**Planning Application Reference 6/2018/0225/HOUSE**

I wish to comment on the above revised planning application, the original application having been refused.

First Floor Plan

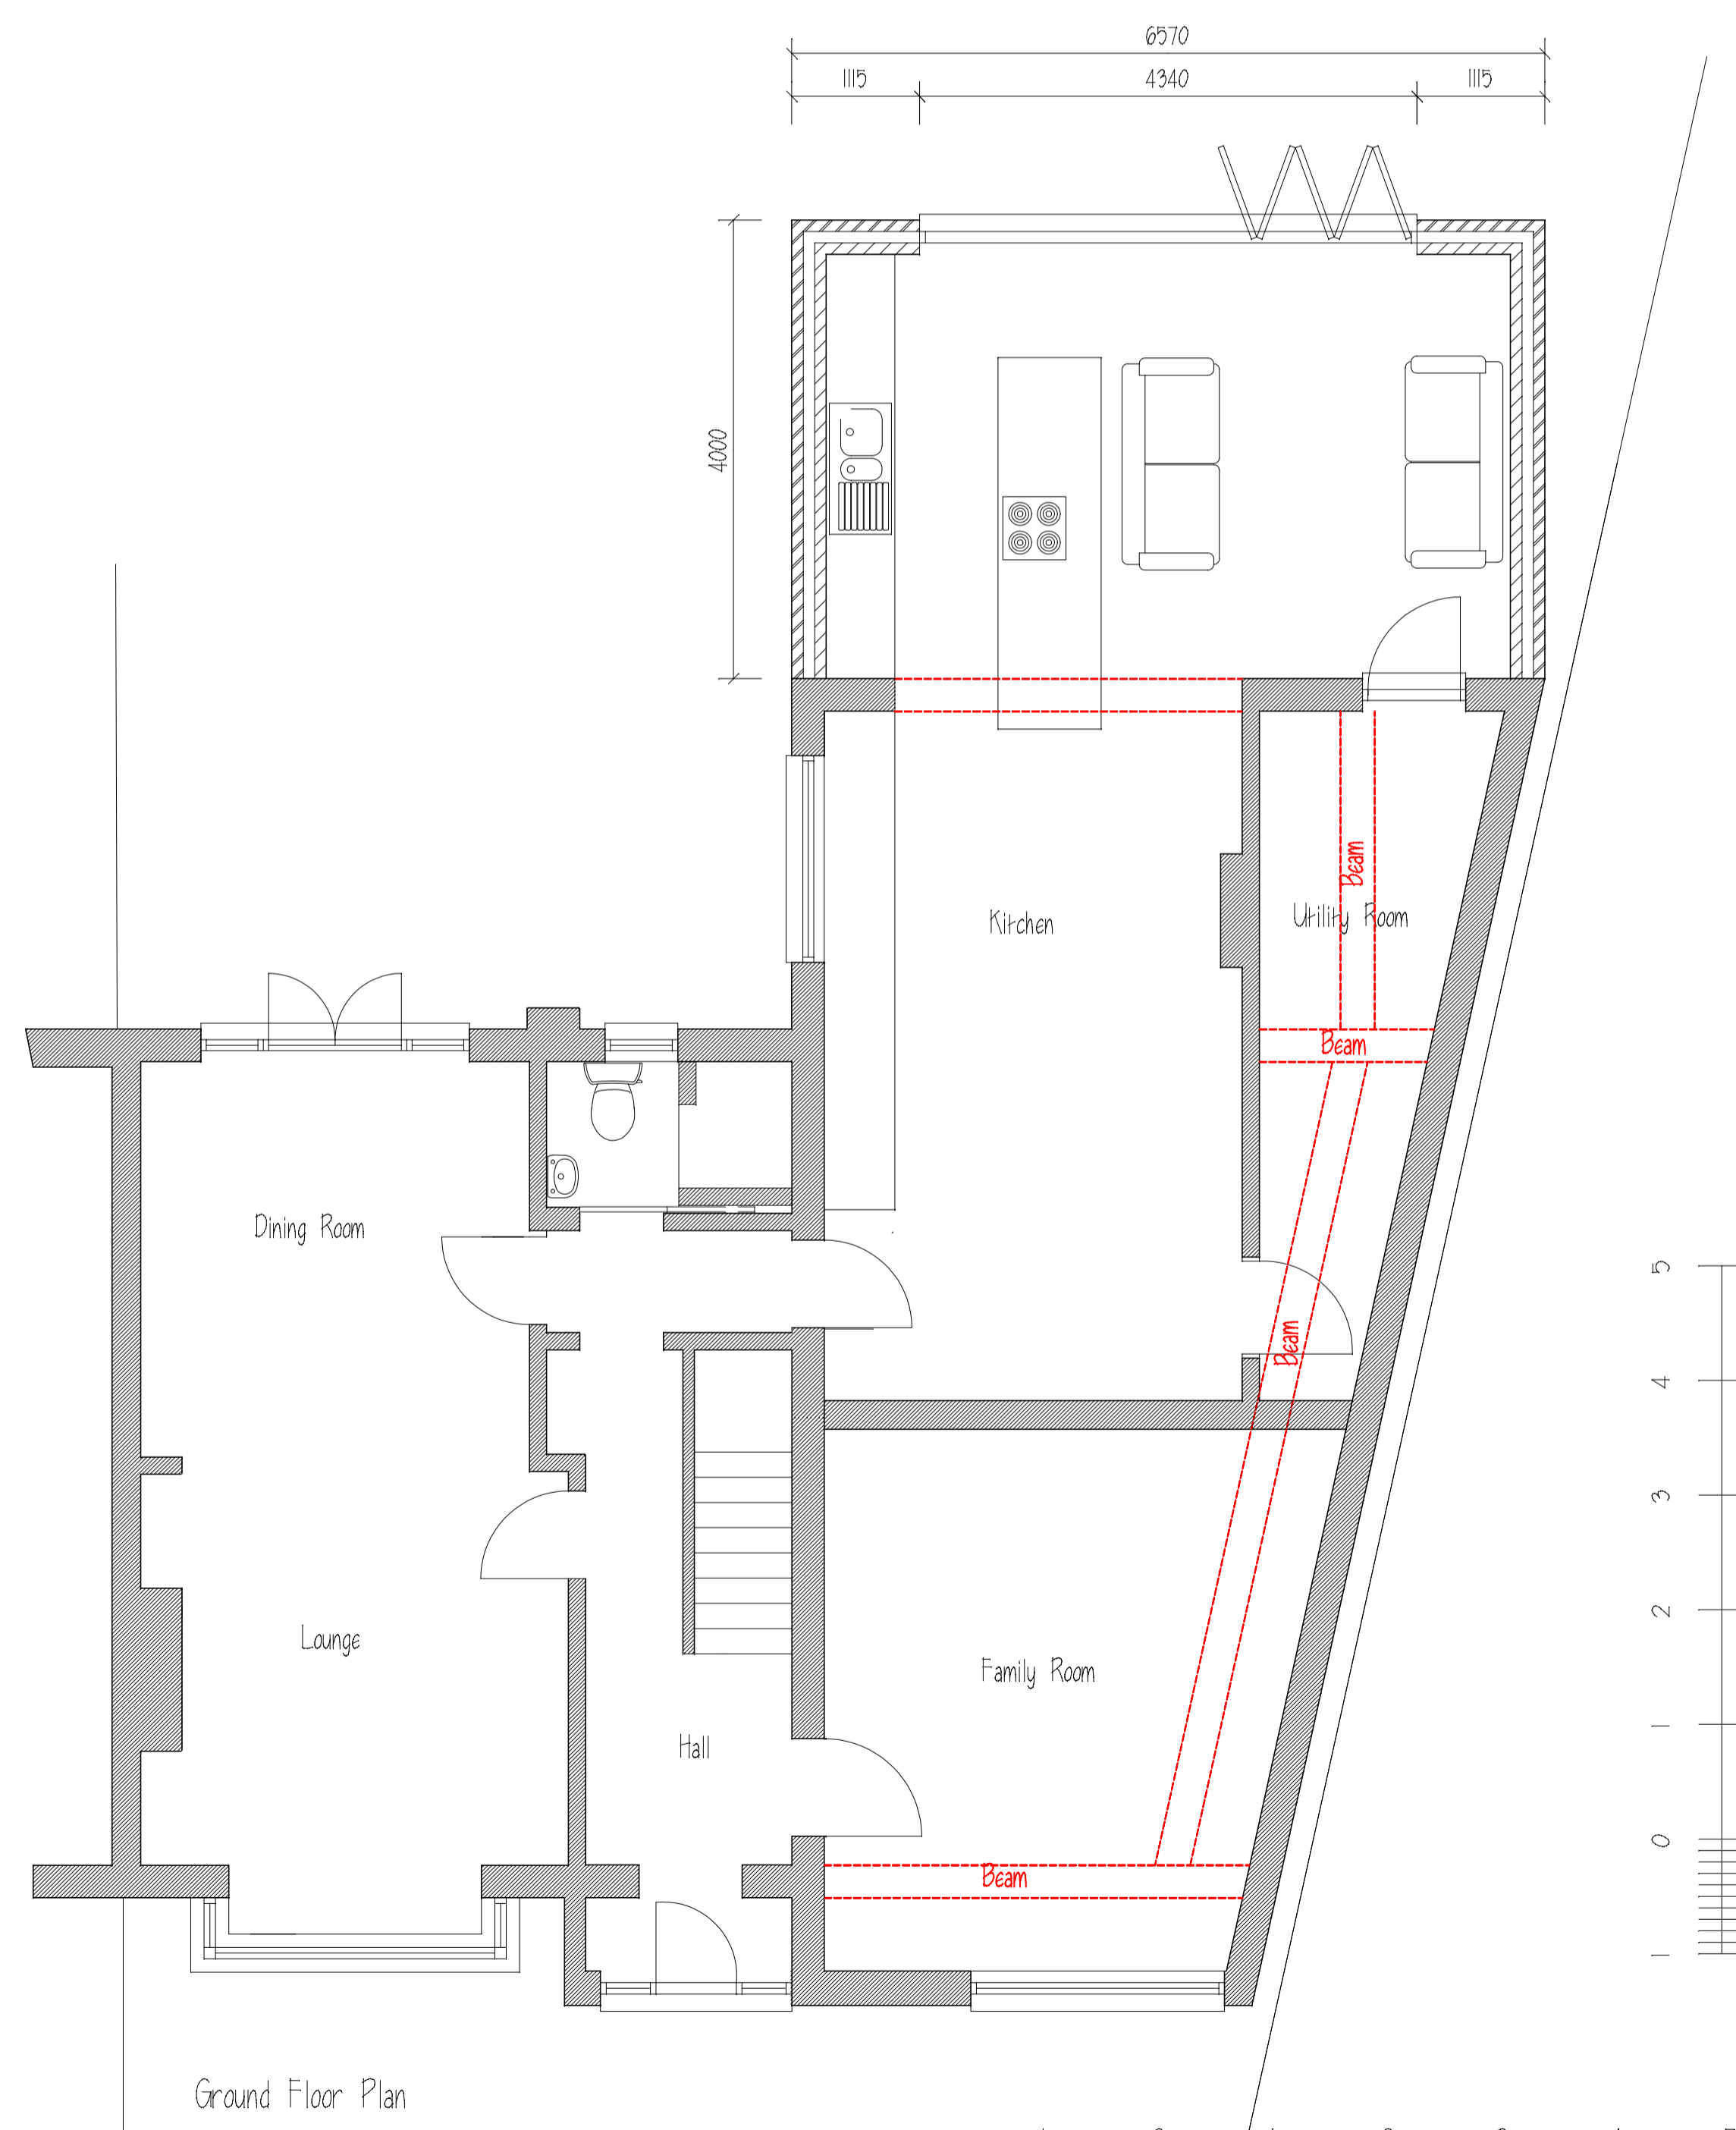
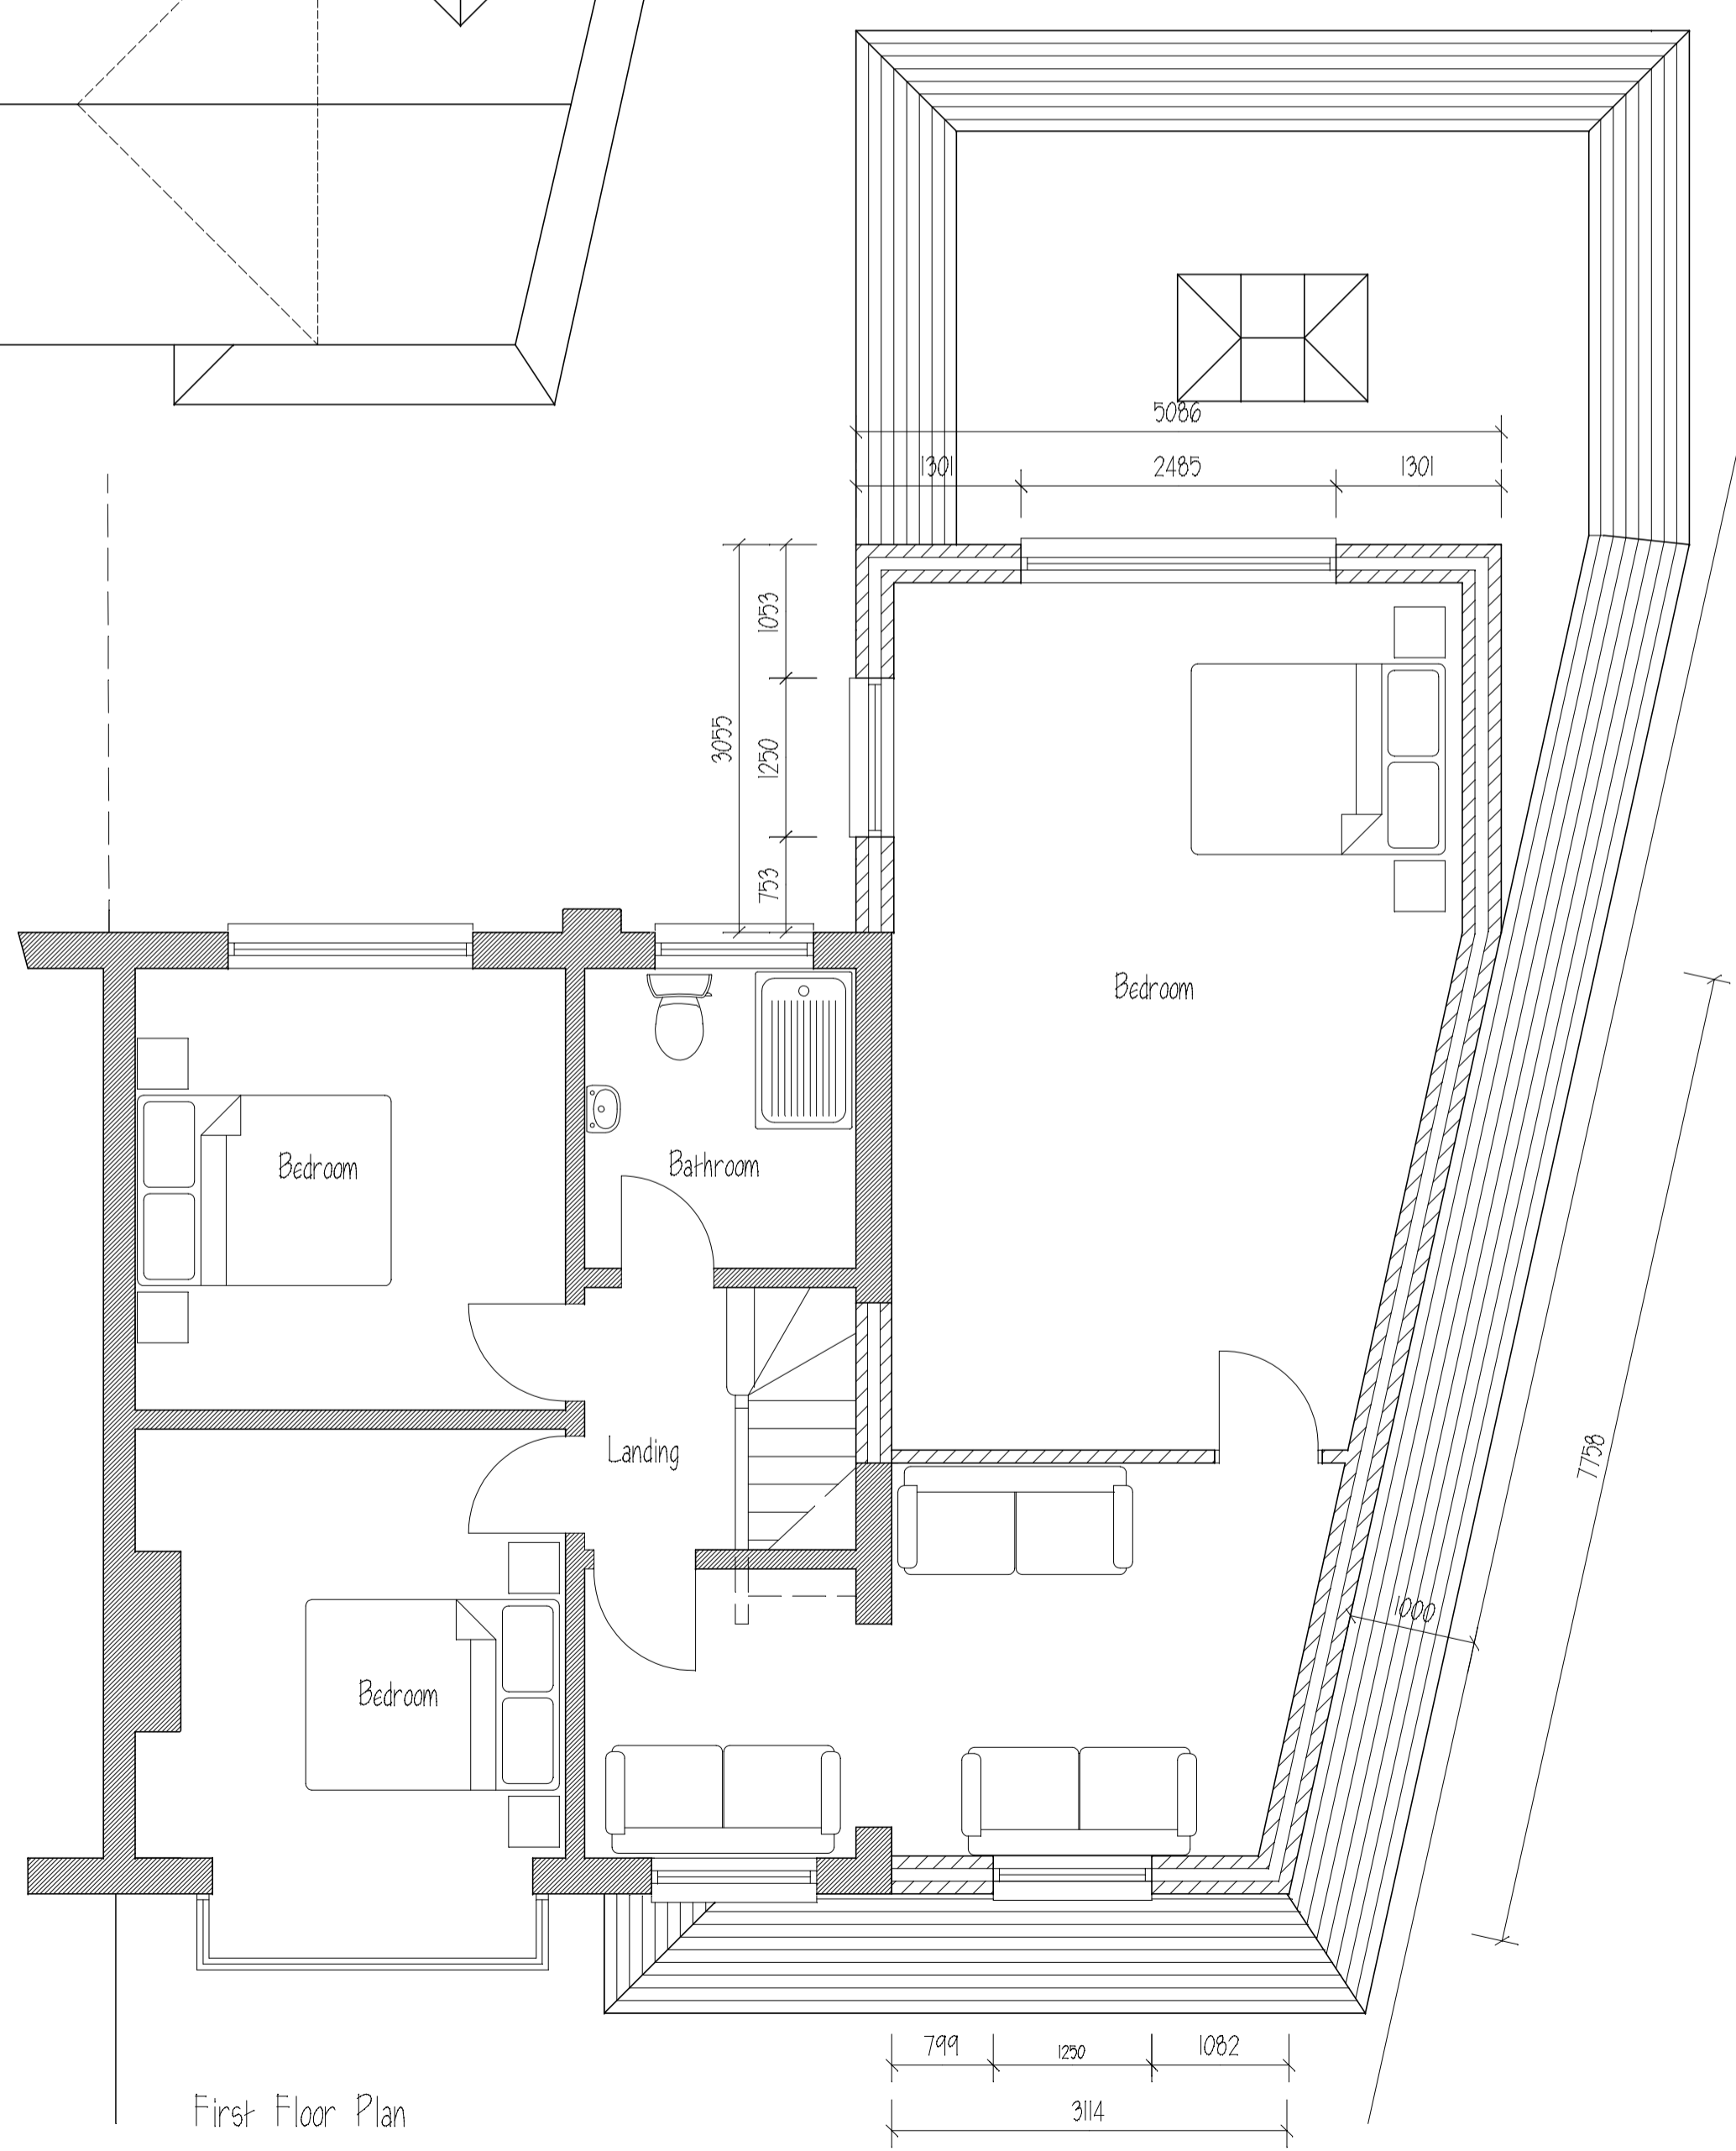
The ground floor extensions at 31 and 33 Selwyn Crescent are only approximately 1 foot apart from each other's boundary. From the revised plan, and as a result of the first floor extension no longer running to the boundary of the existing ground floor extension, it appears that there will now in excess of a minimum 1 metre gap on any first first-floor extension and neighbouring boundary.

The revised first floor plan is more in keeping with similar extensions in the street and therefore my previous objection is withdrawn.

The revised planning application has now removed the proposed 3 windows on the side of the extension and therefore my previous objection is withdrawn.
